# PORTLAND MAINE

RE: Staff Review Comments for Single Family and Level II Site Plans

Project Name: Pomeroy Street Single Family Home & Street Construction      Project ID: 2012-471  
Applicant: Chabad Lubavitch of Maine, Inc.      CBL: 193-E-1  
Planner: Nell Donaldson

SHEET
7

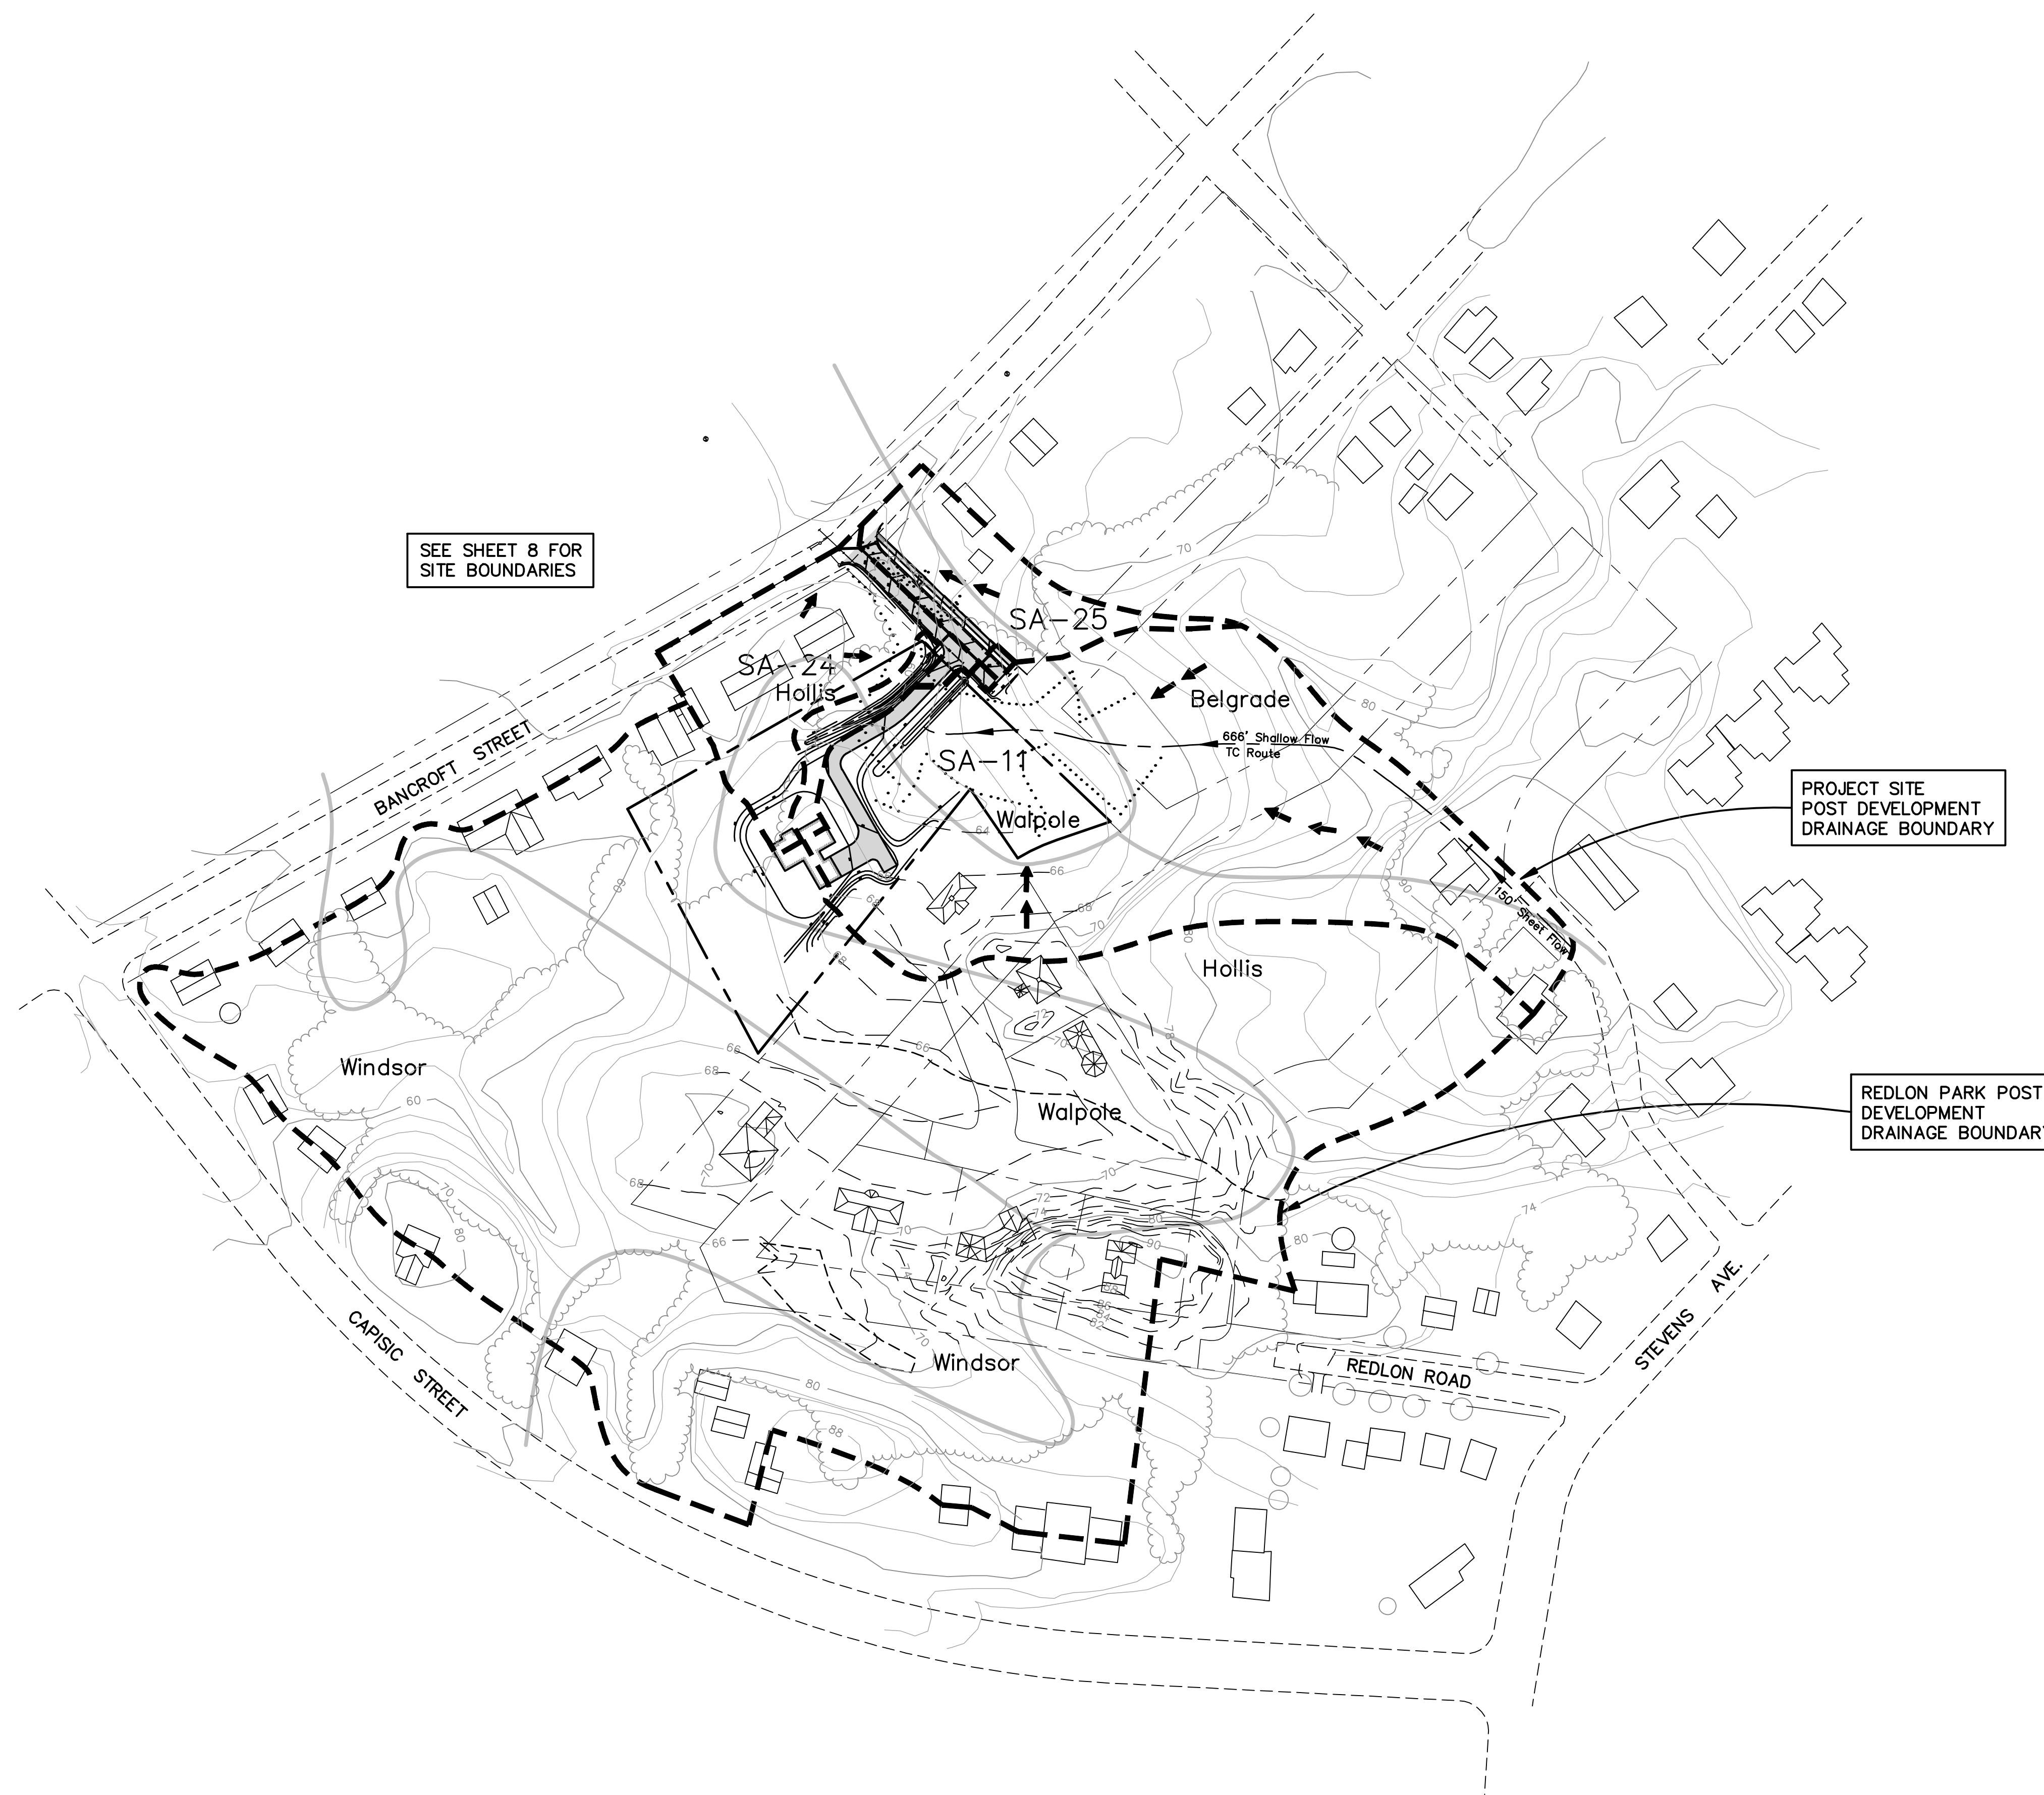
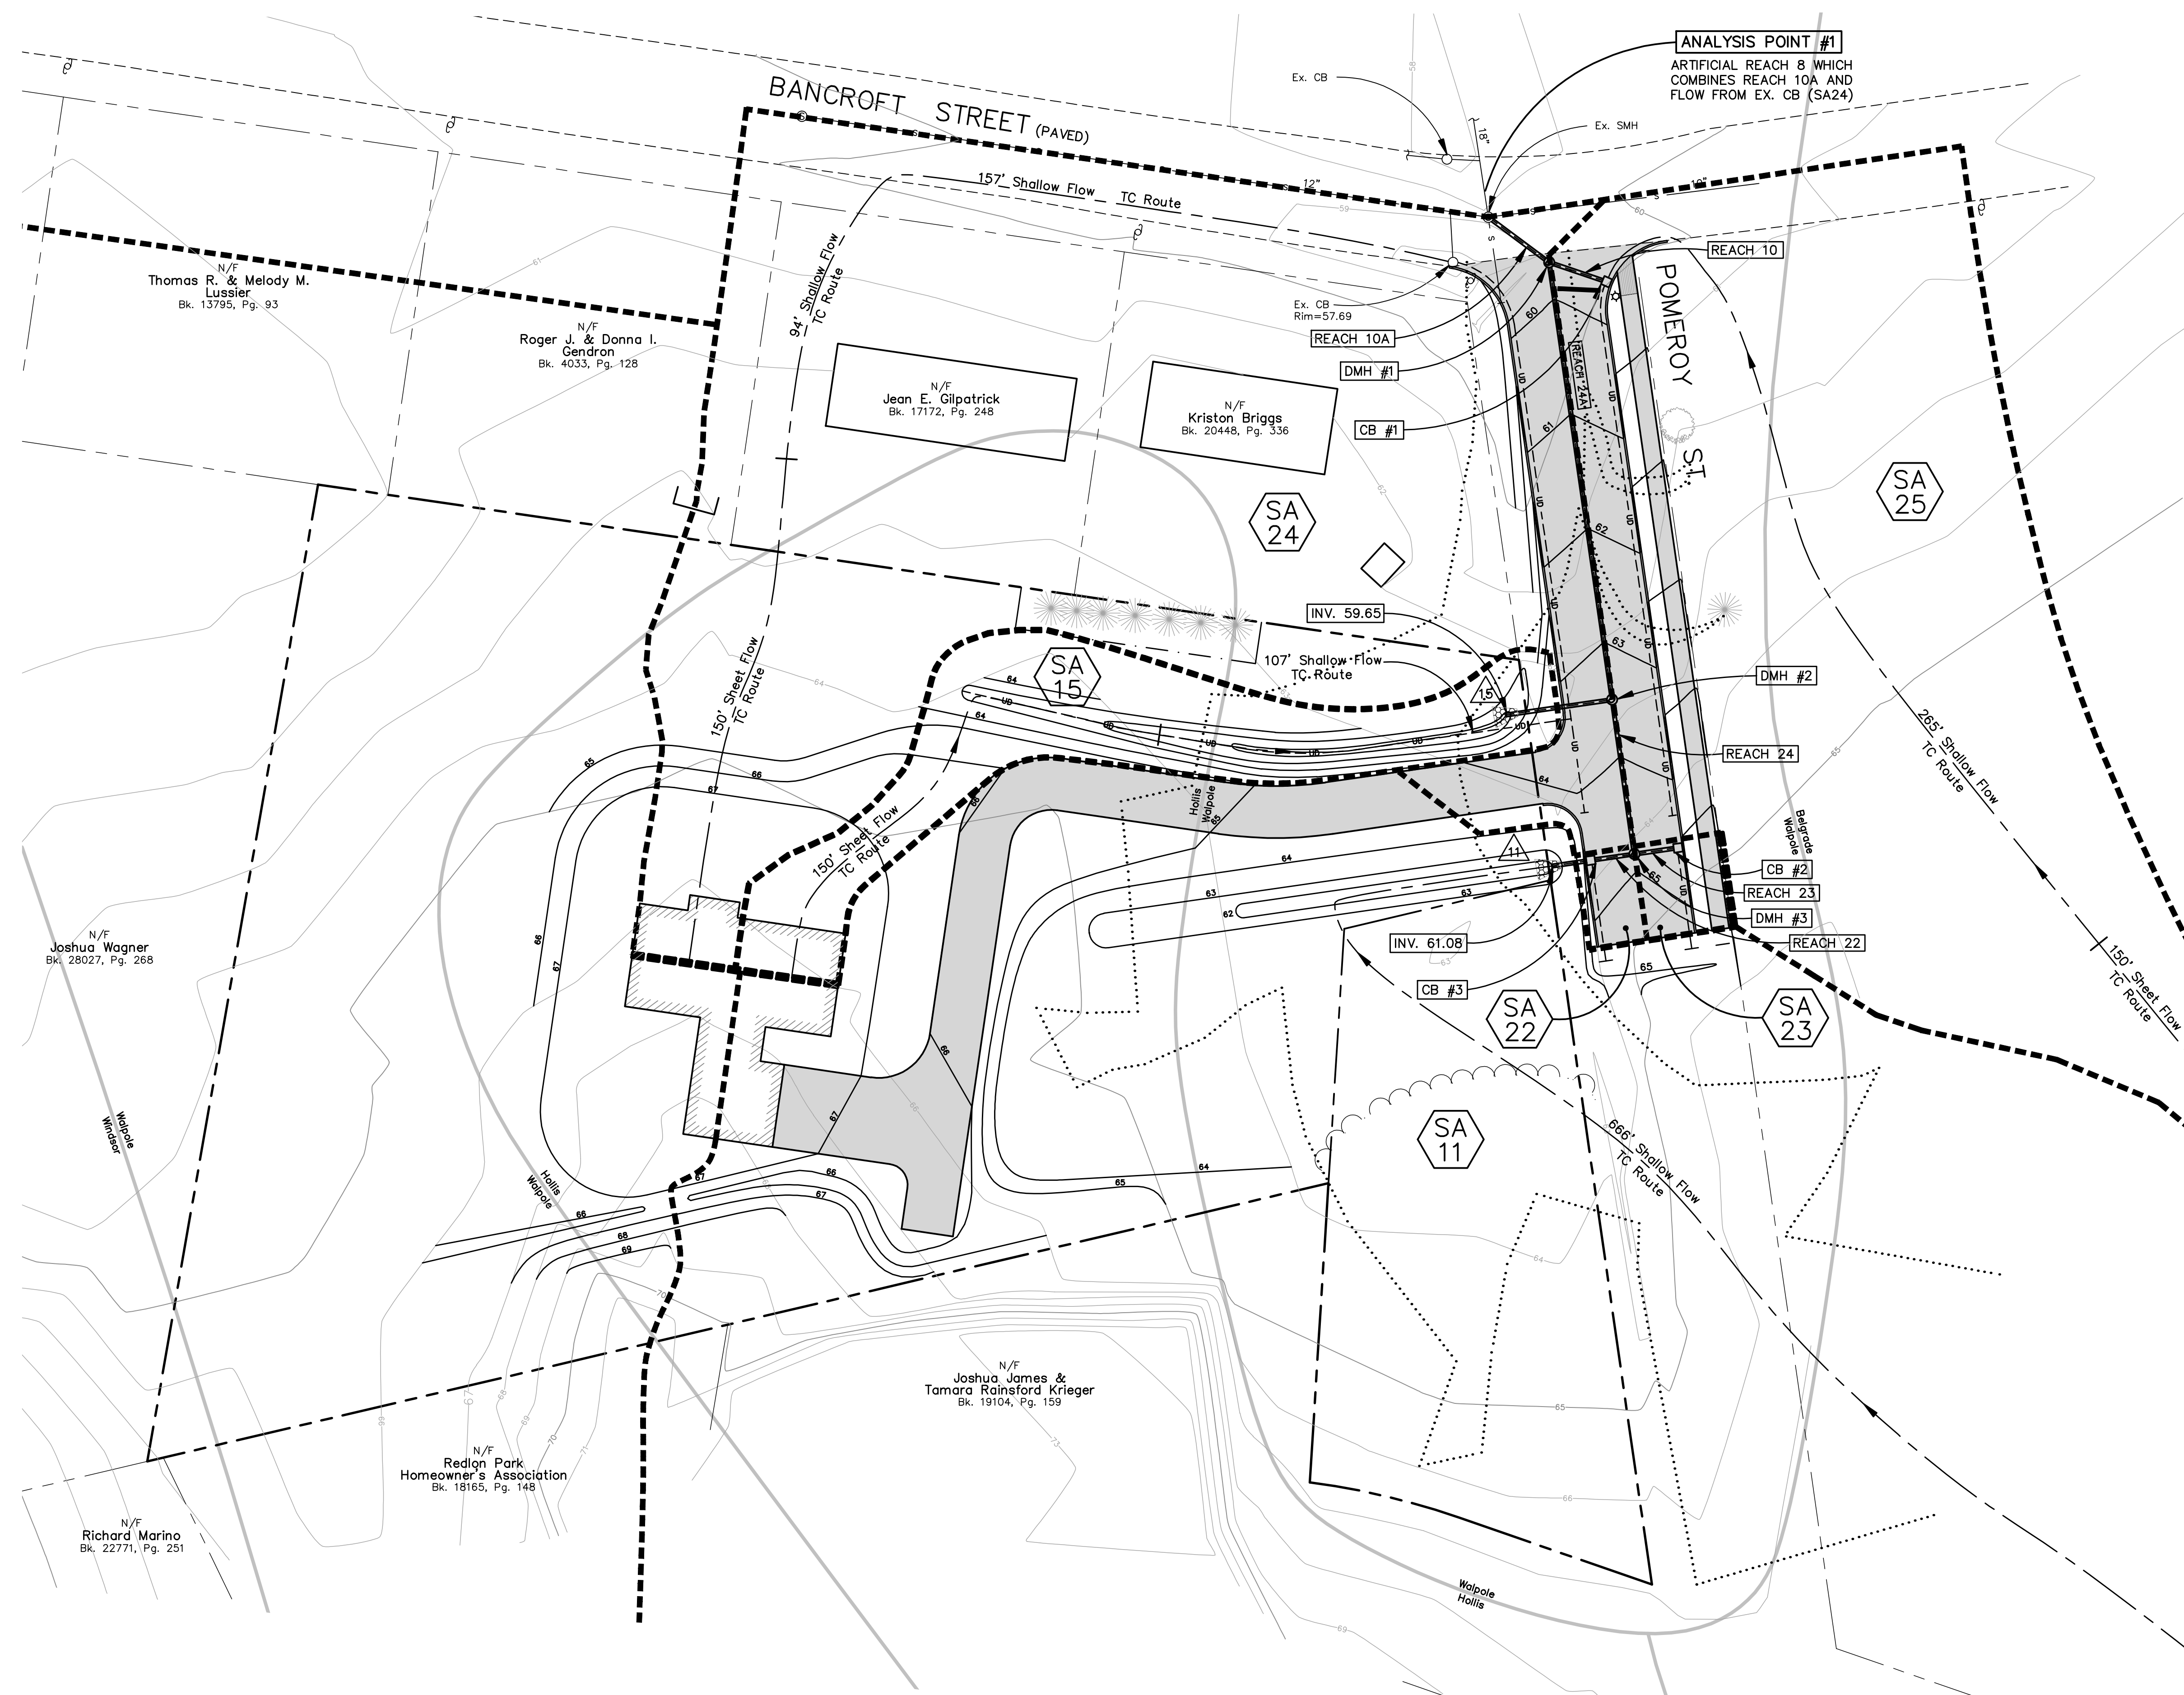
Regarding your response to comments on the Flooding Standard, David Senus writes, *The time of concentration lines for SA-1 (Pre) and SA-11 (Post) are shown on Sheets 6 & 7. These Tc lines show a 150' length of SHEET flow at the far east edge of the drainage boundary. Because there are no proposed changes in this area, the HydroCAD model should reflect the same slope and cover type for this 150' length of sheet flow in the pre & post condition. Please revisit the model and adjust accordingly.*
